From: [REDACTED]
Sent: 20 December 2018 14:15
To: Planning.Responses
Subject: R/275/18/HH Planning Permission URGENT

Re your letter dated 19th December, I am aware of the plans submitted for planning permission at 36 The Parkway, Rustington BN16 2BU, and wish to make the following comments.

Proposed Elevations

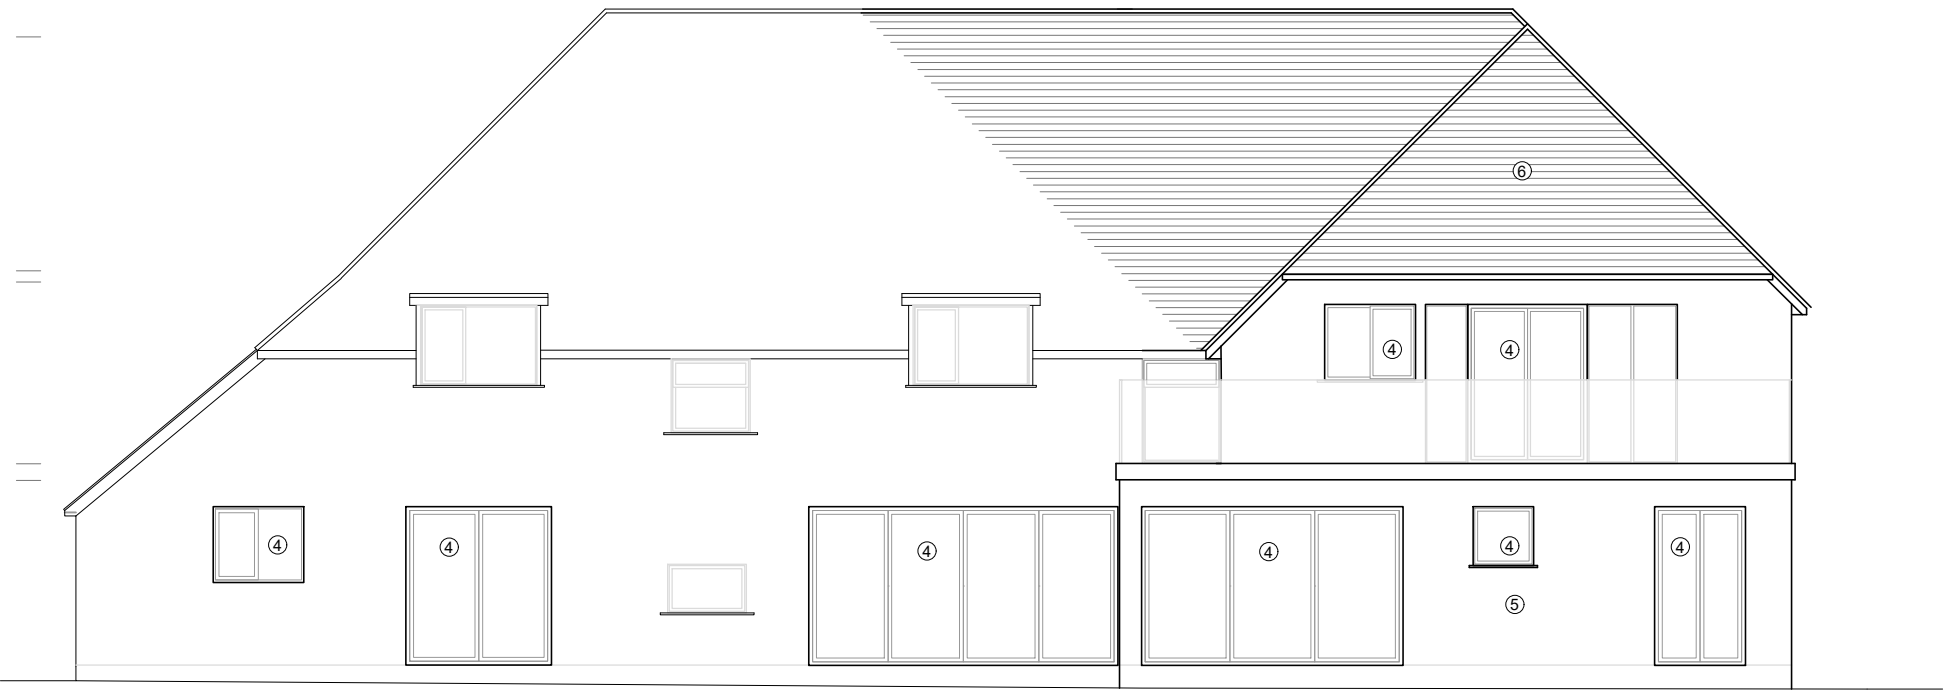
2. Regarding the Return End on your proposed balcony at the rear of your extension, please confirm that this will be either a Solid Wall or Frosted Glass Panel construction to ensure the privacy for both parties.

Proposed Floor Plans, Block Plan and Roof Plan

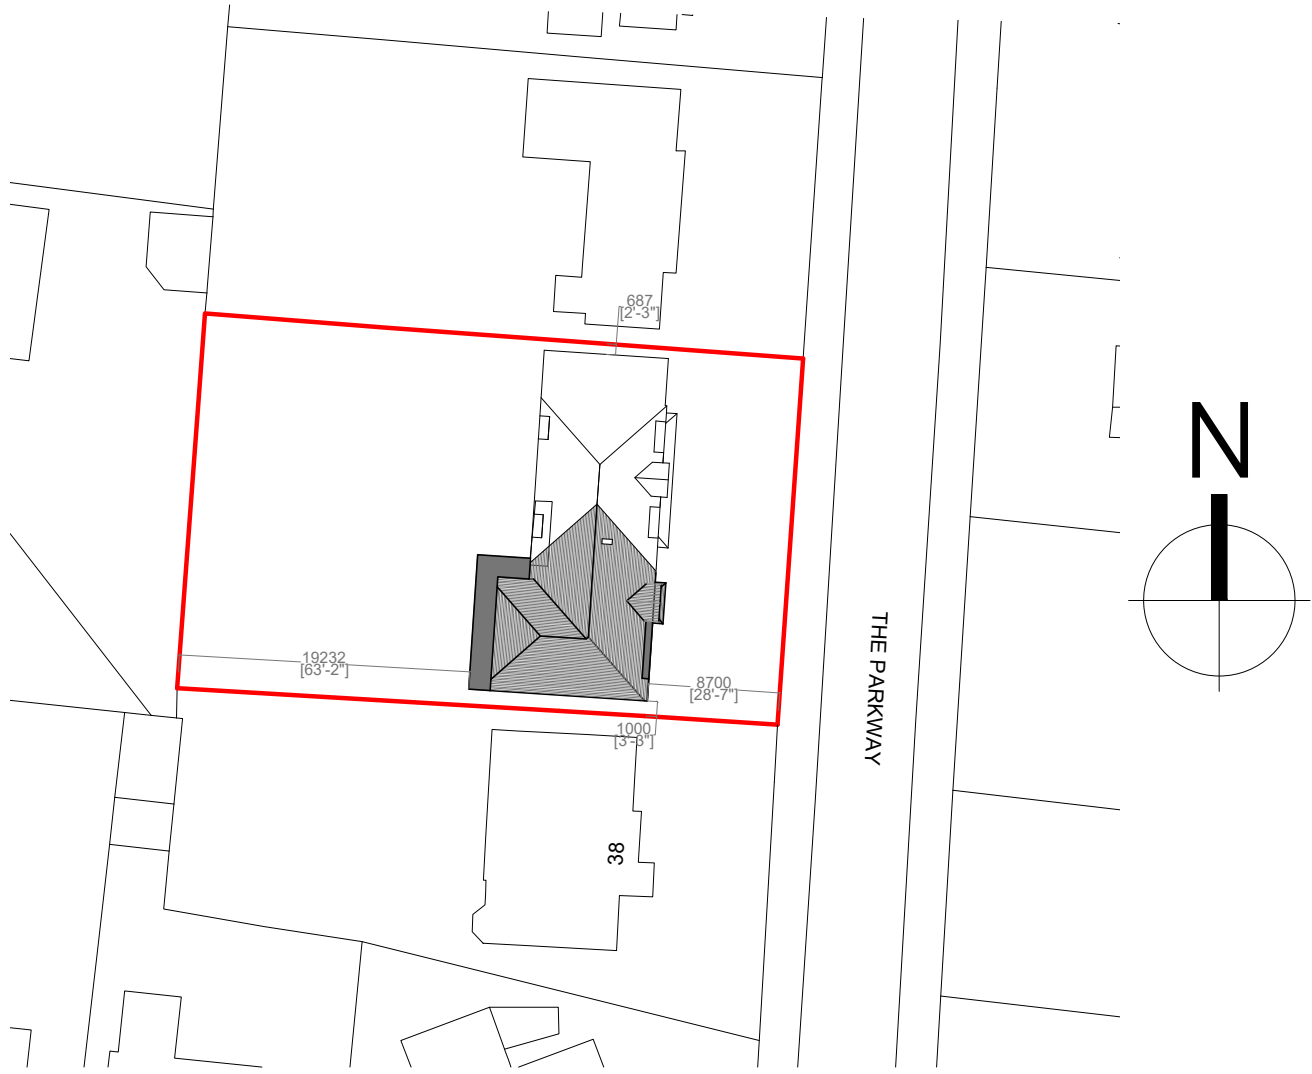
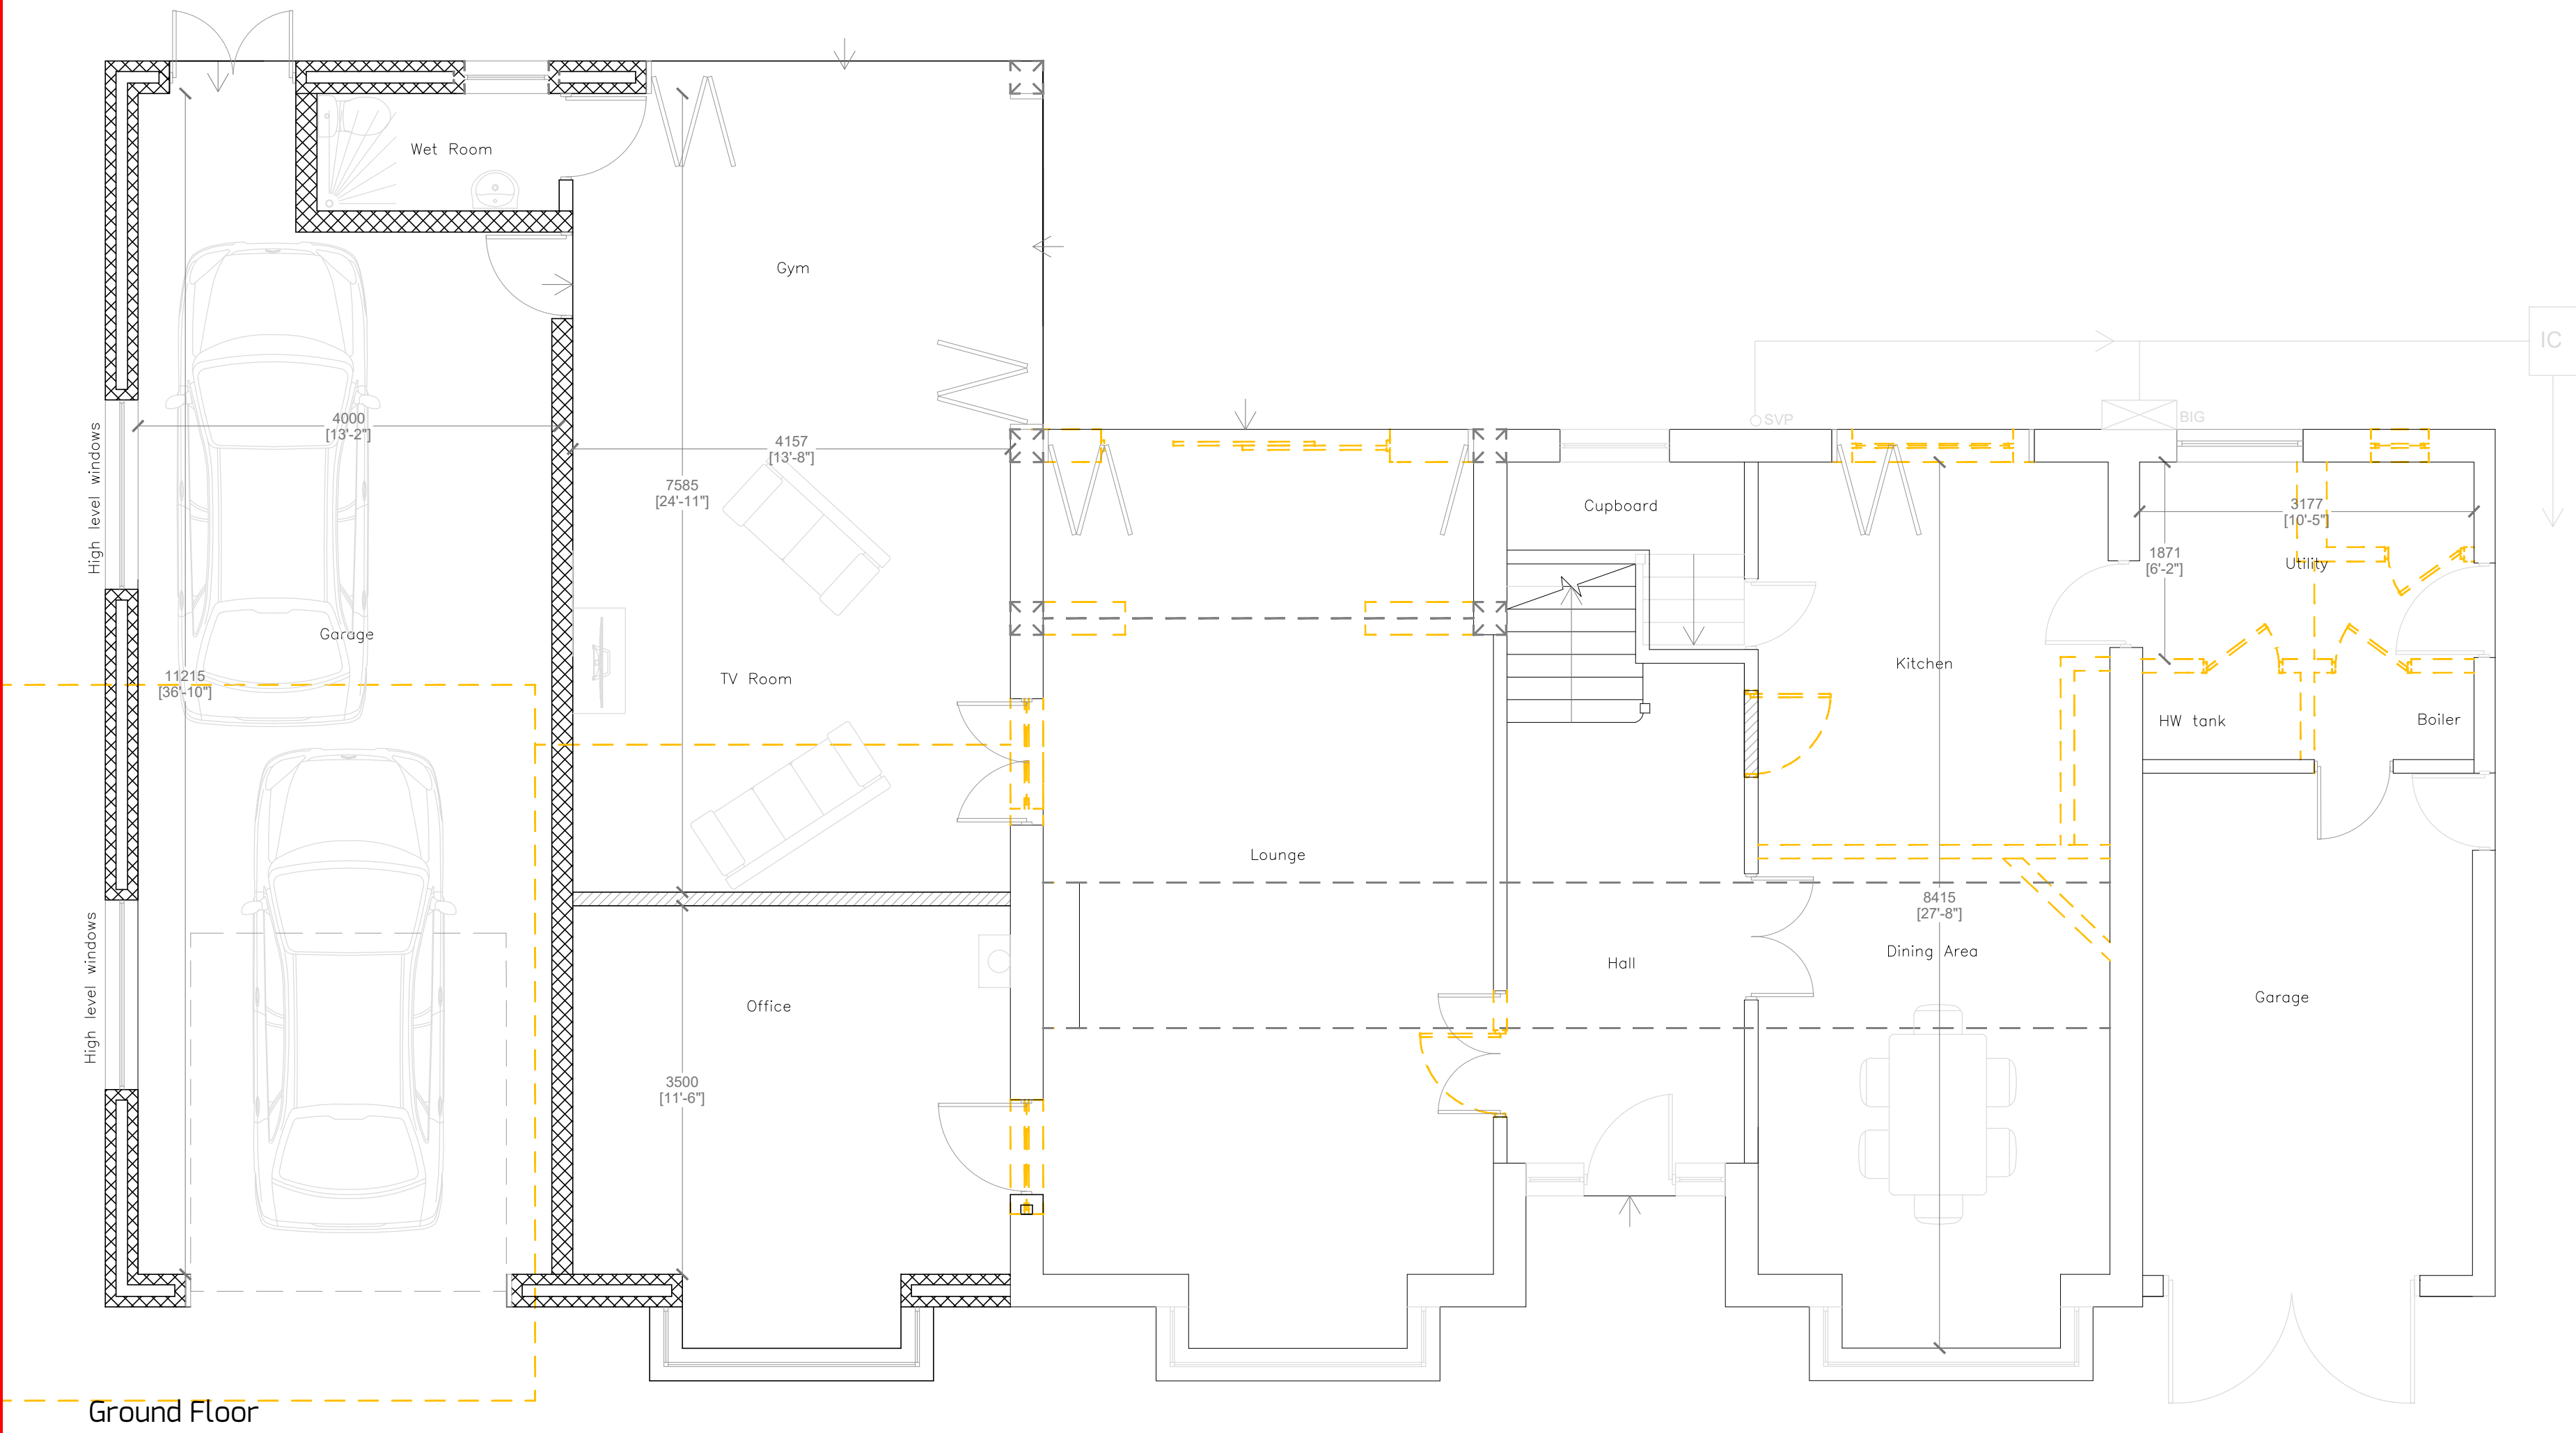
1. We understand that because the existing garage on the south side of your property partly forming our boundaries, will be demolished to erect a new Two Storey Dwelling, we need to discuss re-instatement of the original boundary, allowing for secure access to our back garden.

Assuming that the New Build will take a considerable amount of time to complete, we request that when your existing garage is demolished, that a 6ft. boundary fence or wall with gate be erected at the start of the build in order that our property remains a secure area at all times.
